16 November 2020

Our ref: *D2020/119877*

**Re: Western Sydney Energy and Resource Recovery Centre – EIS Exhibition (SSD 10395)**

STORMWATER PLAN SHEET 1 OF 2

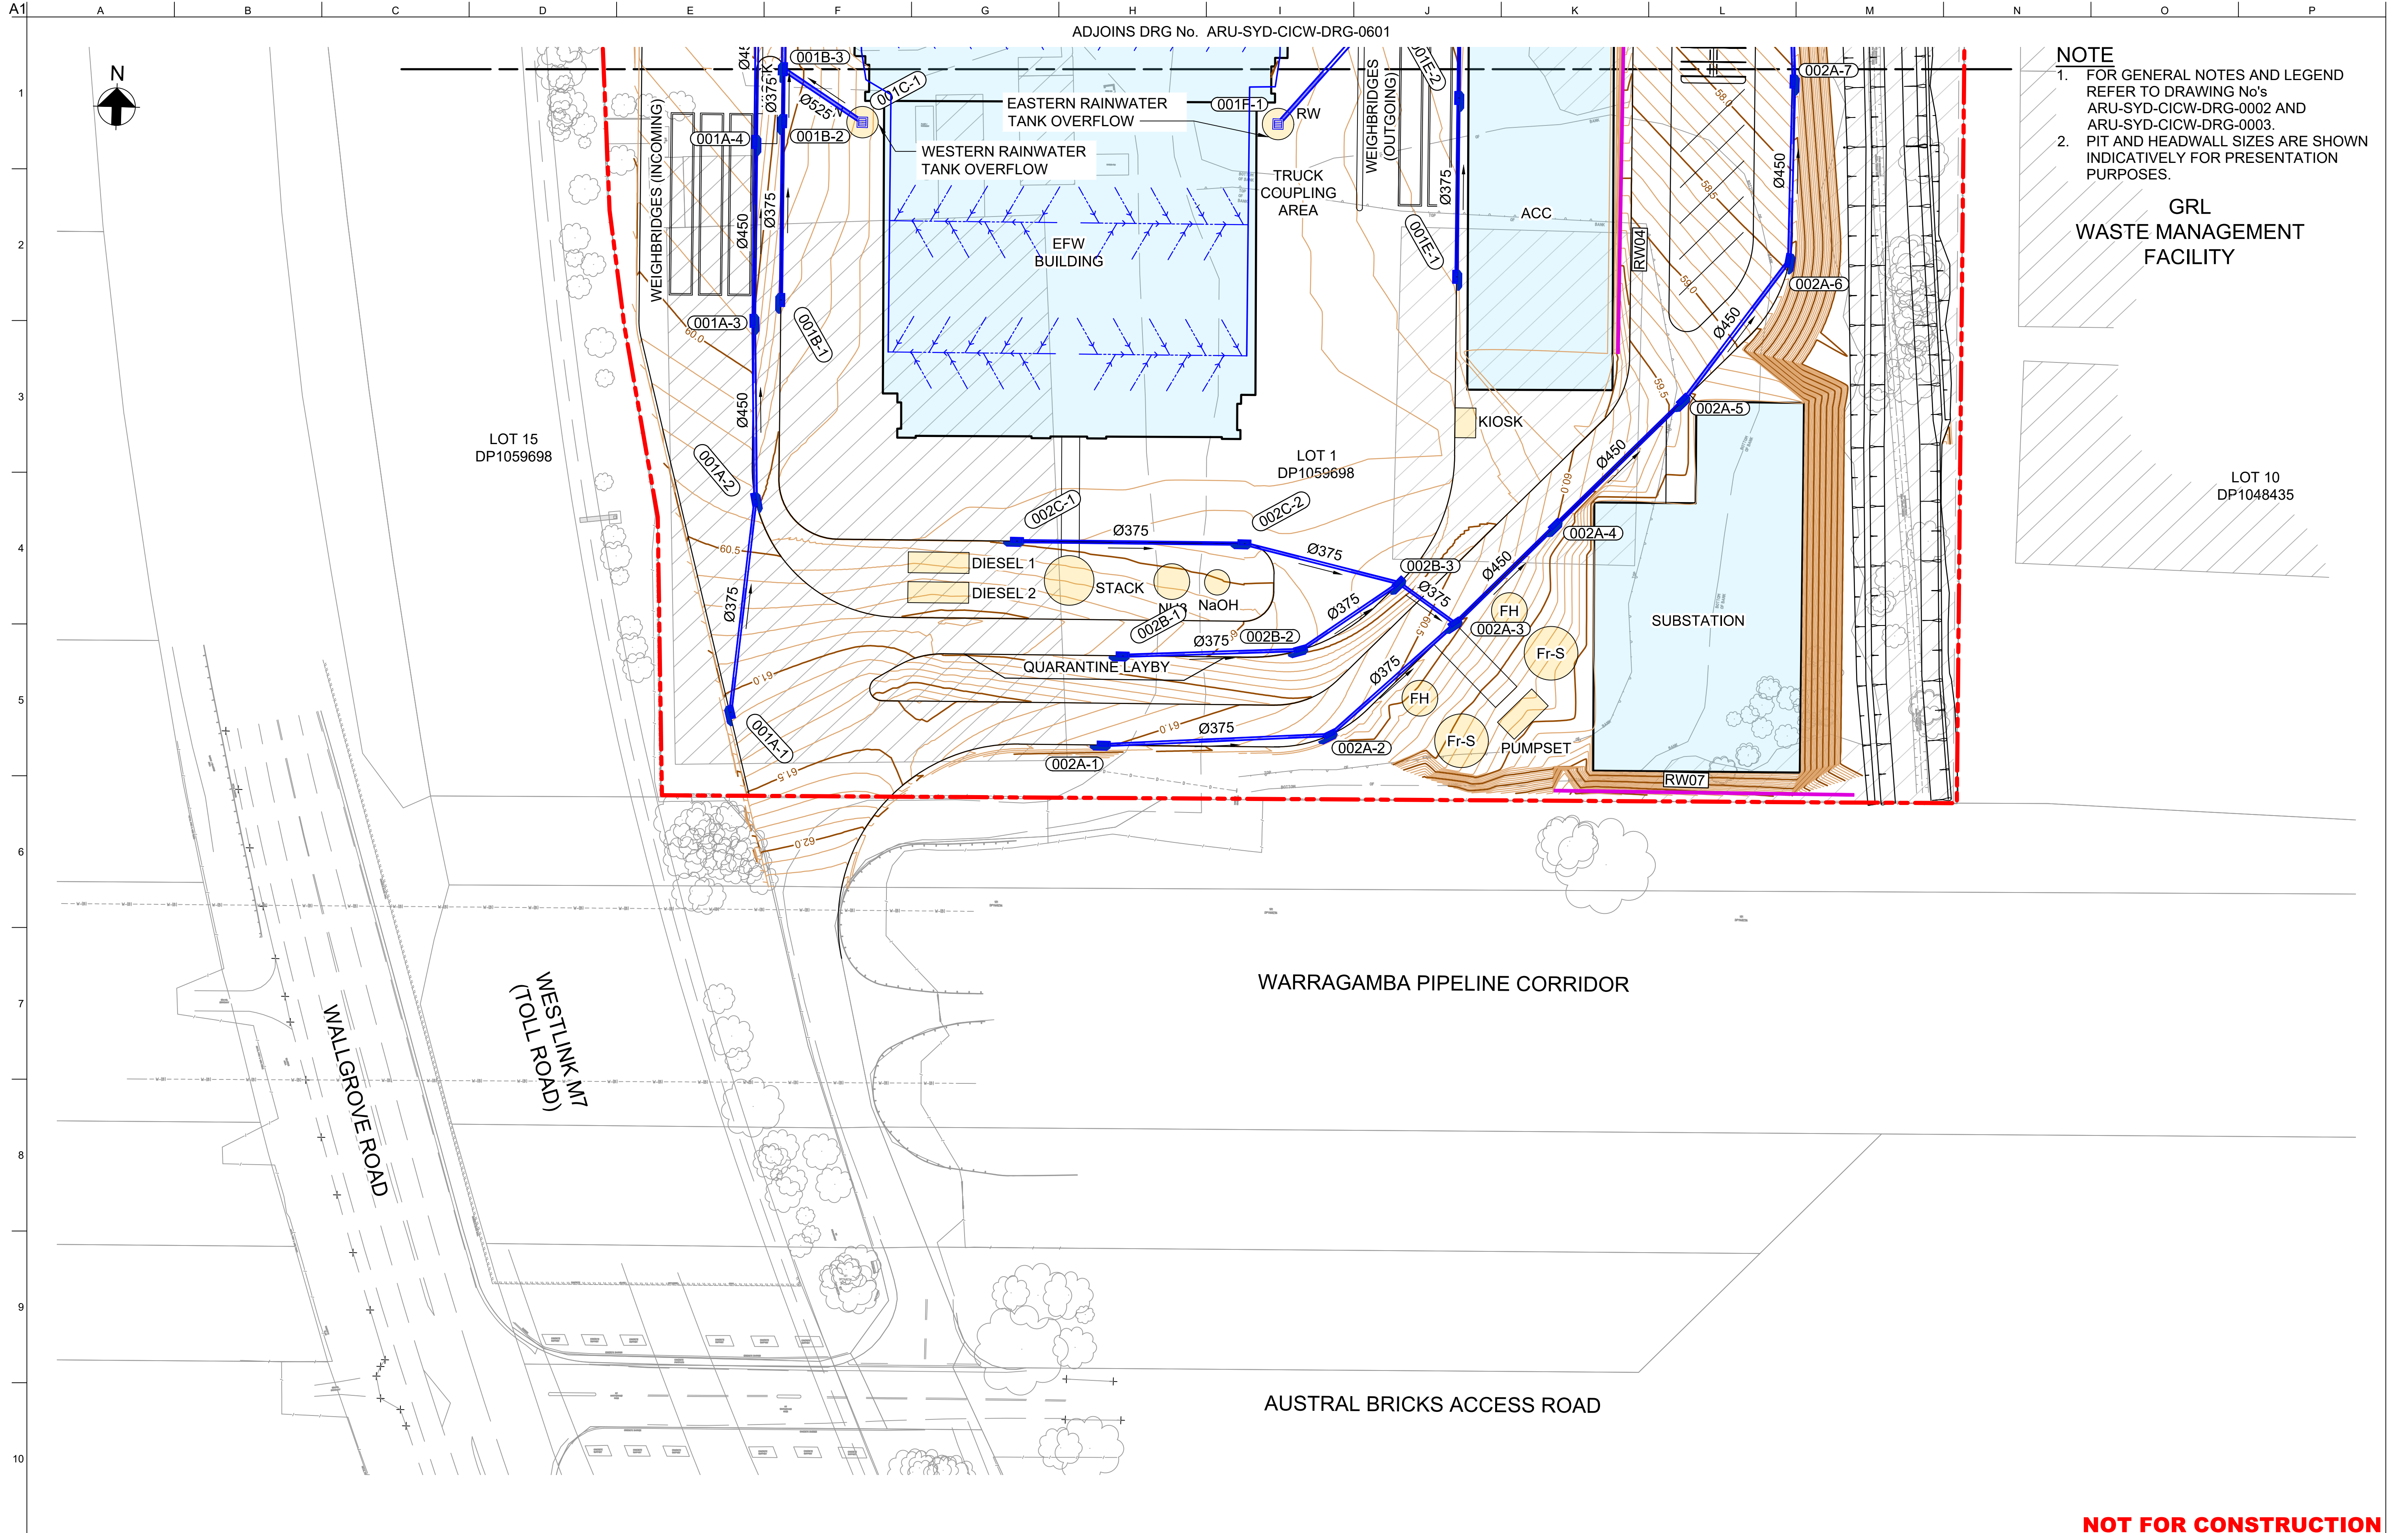
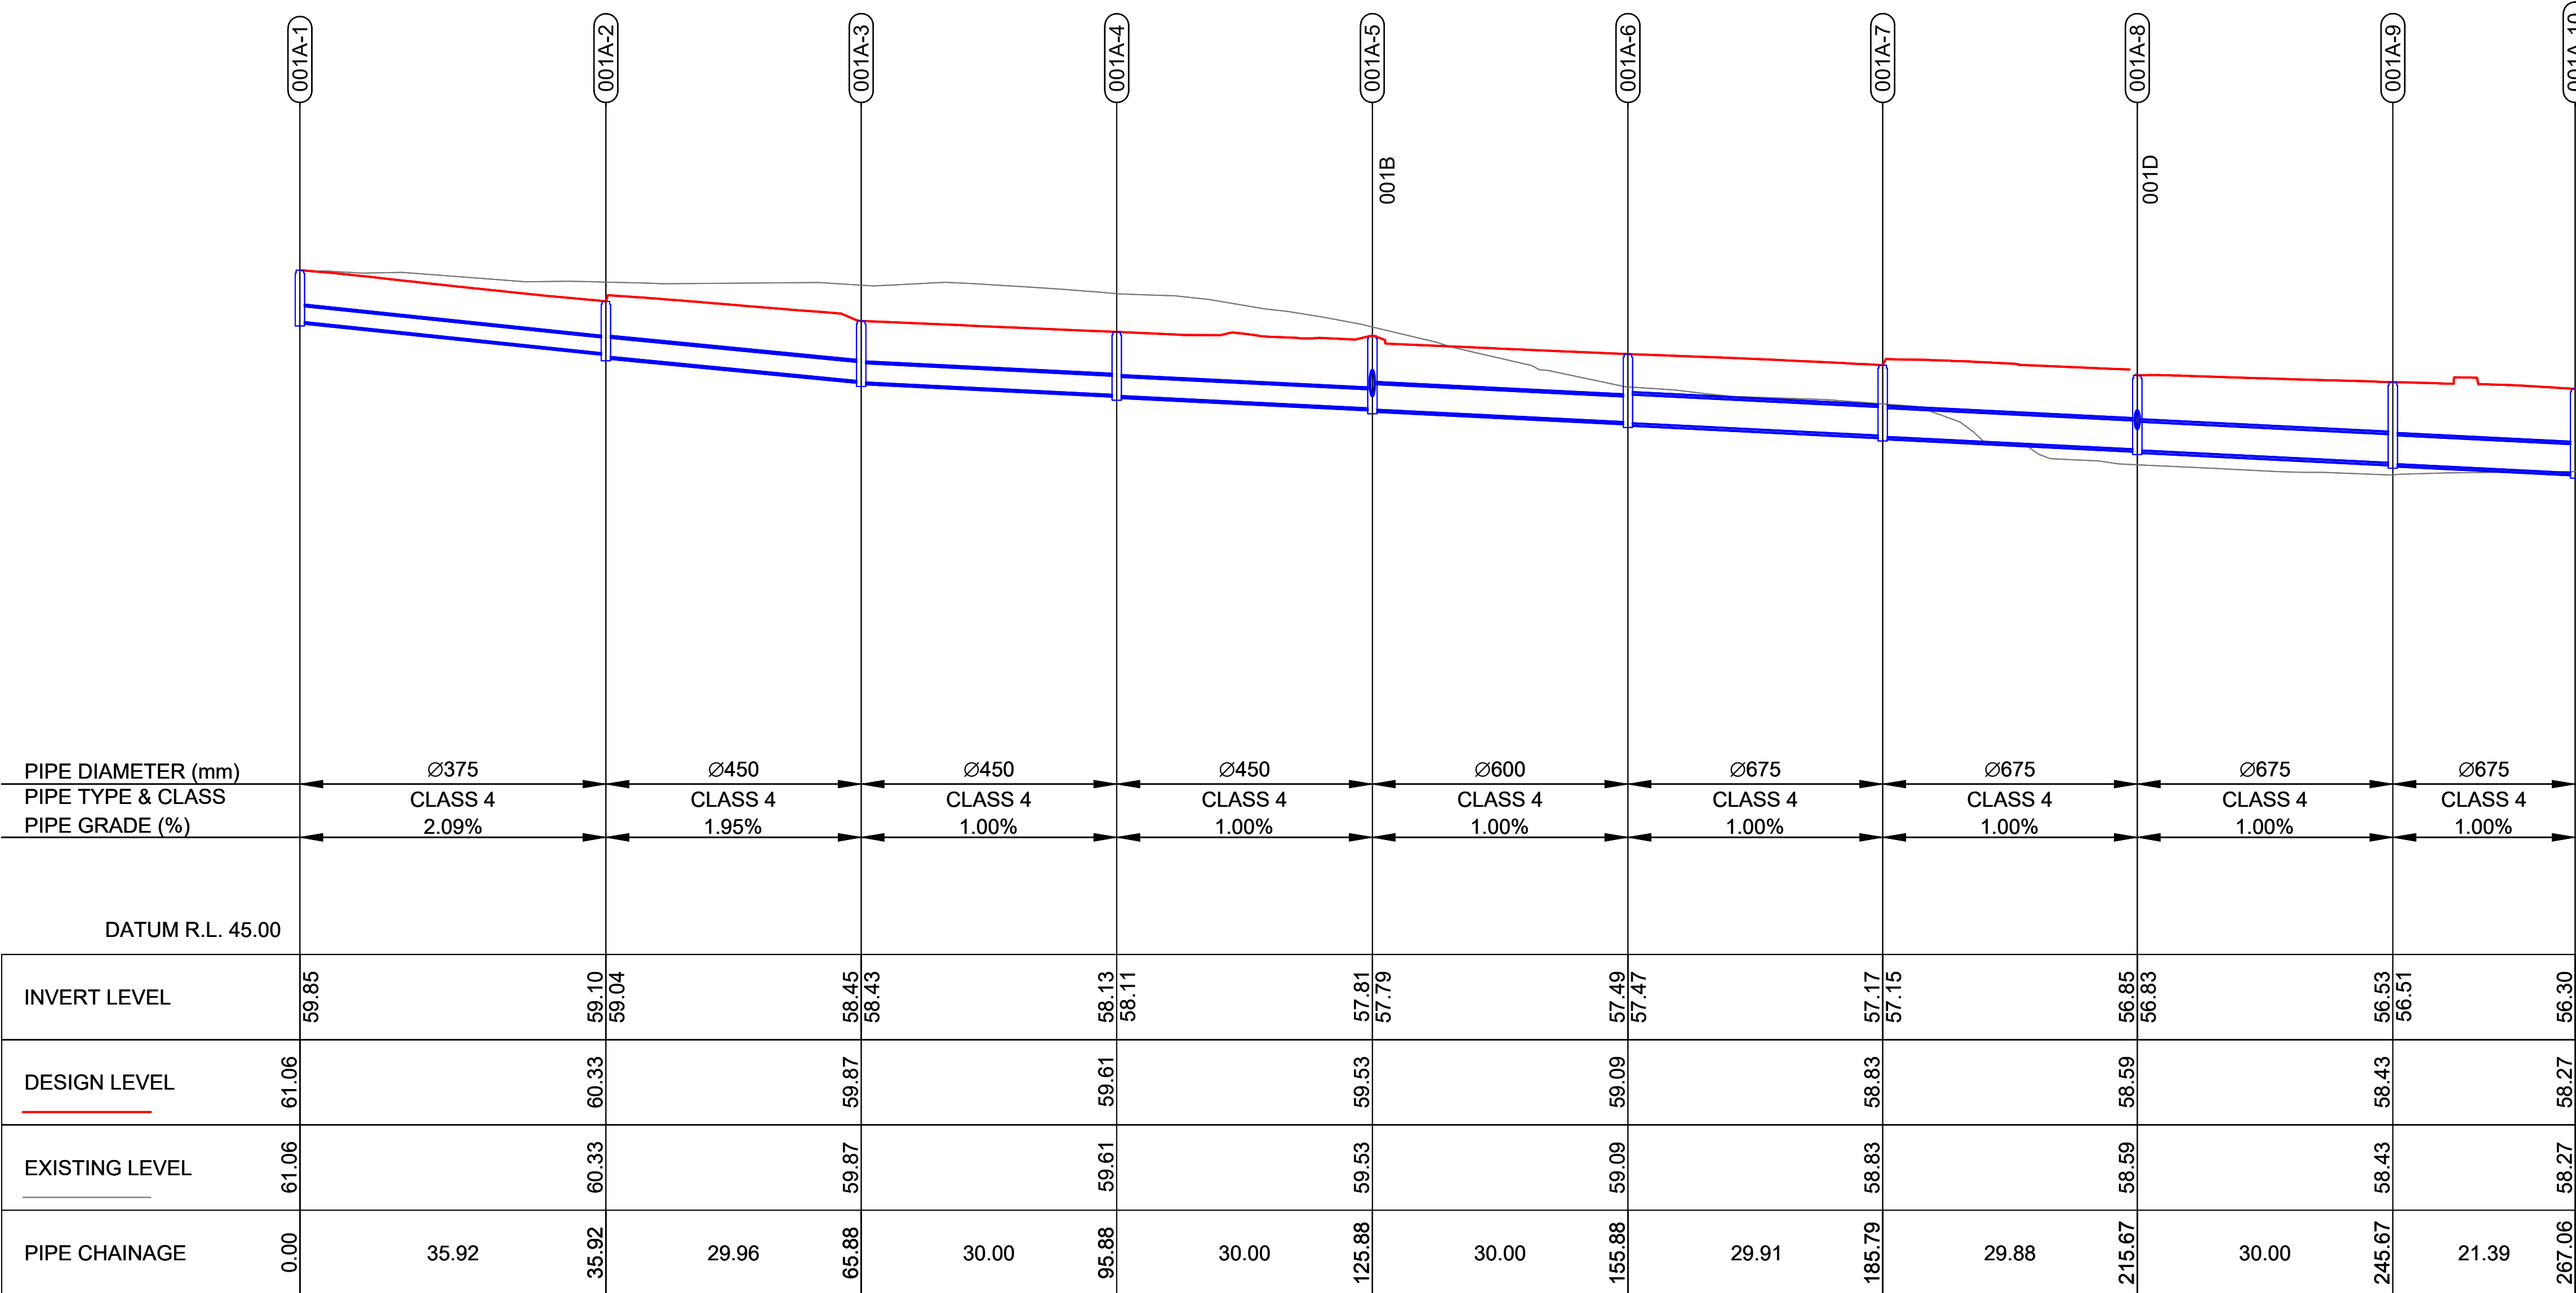
Stormwater flows across the Pipelines corridor from south to north and into a drainage line at the east of the subject site. Both Pipelines also have scour valves that drain towards the site when exercised and these additional flows must be taken into account when designing stormwater management systems for the proposal.

As identified in Technical Report H, the site is also potentially impacted by flooding. All stormwater flows, up to 1% AEP flood event flowing across the Pipelines corridor must be accommodated by development on the subject site. Development must not occur that impedes the flow from the Pipelines corridor causing it to pool in the corridor and potentially impact the integrity of the Pipeline anchor blocks or sills by undermining, or cause the Pipelines to float or be knocked off their anchor blocks or rupture due to flooding stresses.

- *All surface water from the Pipelines corridor, including from exercising the scour valves, must not be impeded and must be accommodated in downstream water management systems within the development site, up to and including the 1% AEP flood event.*
